From: [REDACTED]
Sent: 20 June 2017 17:52
To: Andrew Wood
Subject: Re: FG 198/16/PL - VERY URGENT

b.) Given that the report states that all windows on the West facing elevation will be obscure glazed bar the bedroom windows discussed above, why does proposed condition 14 only state that all first floor hallway, bathroom and en-suite windows at first floor level in the West and North elevations shall be obscure ? Why are the ground floor windows not included in this condition ? Why, also is the ground floor kitchen / living / dining window and the ground and first floor side windows to the master bedrooms not included in this condition ?

PROJECT: 1 SEA DRIVE
HARRISON WORTHING
BRIEF 5/10
TITLE: PROPOSED ELEVATIONS
AND STREET SCENES

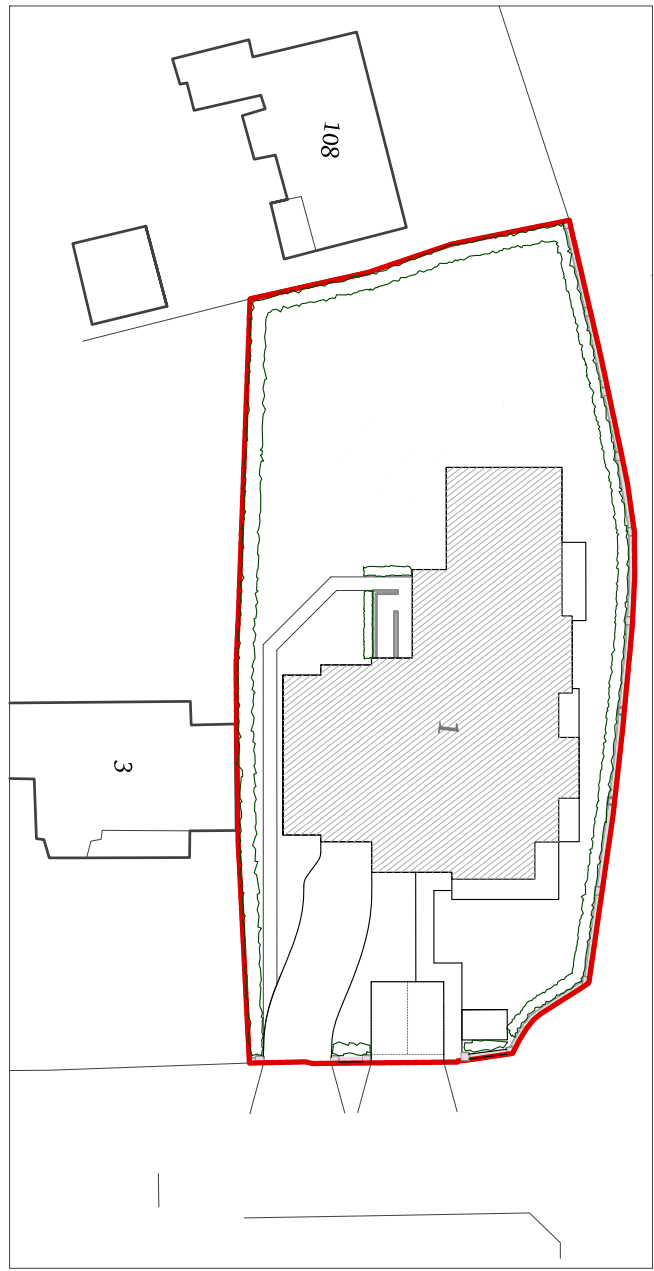
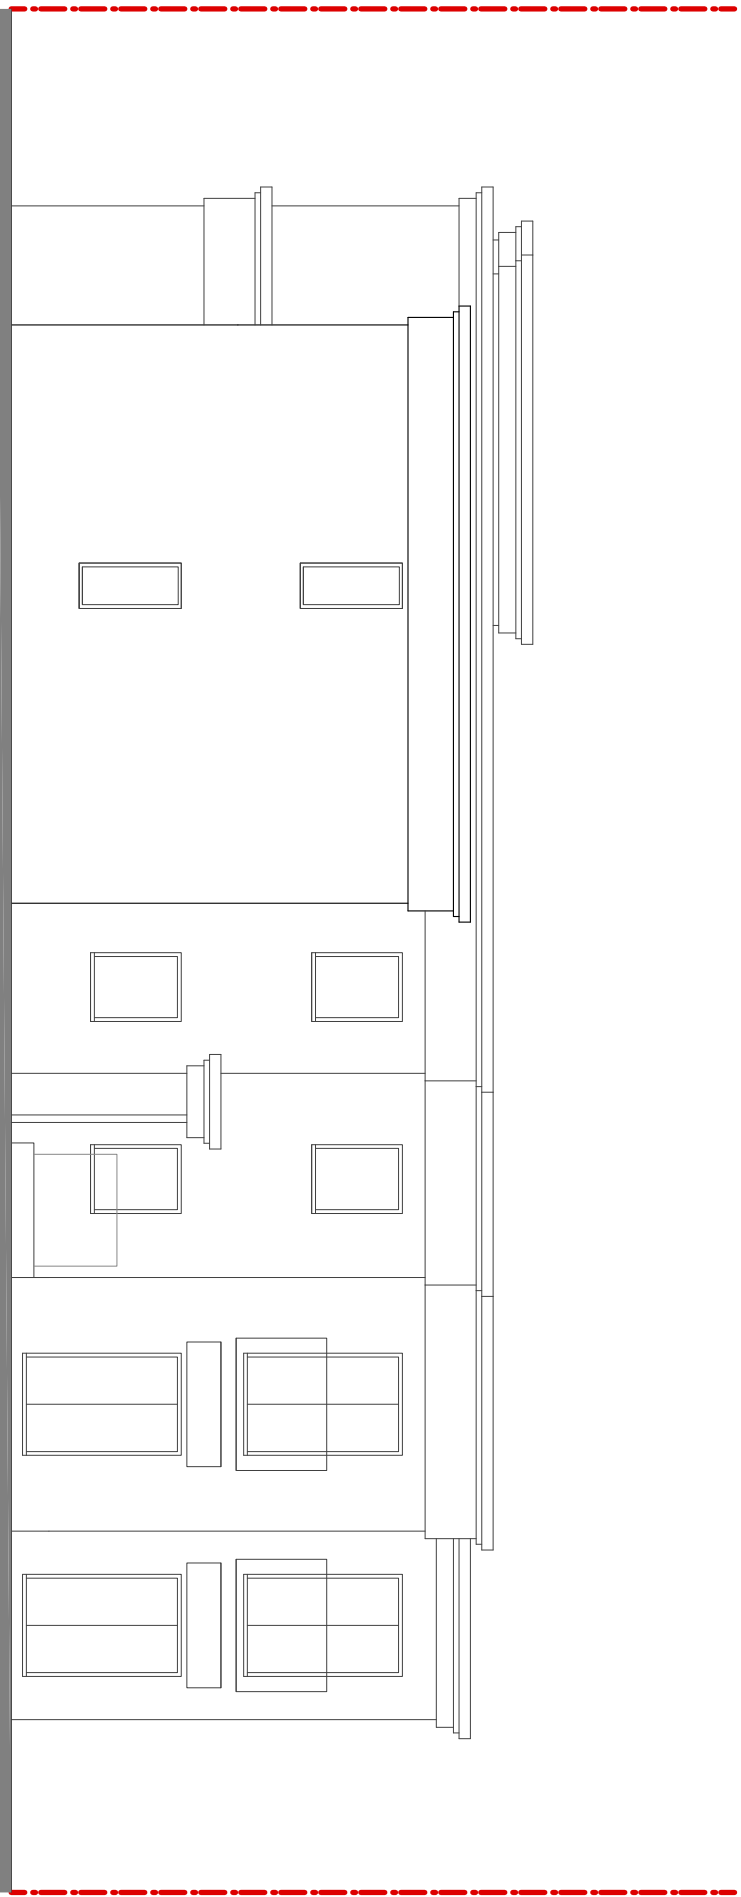
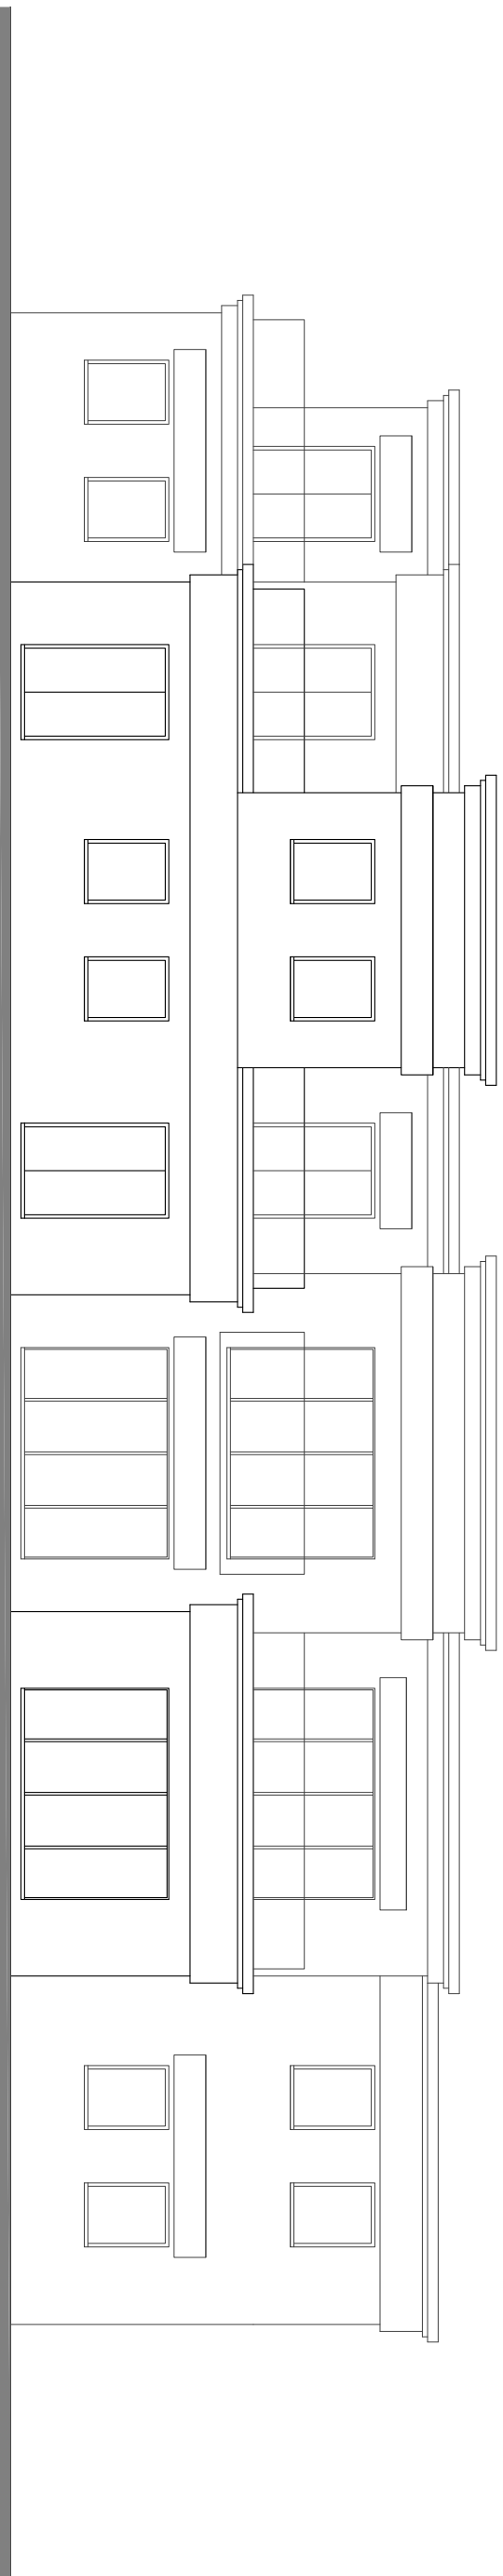
and the ground and first floor side windows to the master bedrooms not included in this condition ?
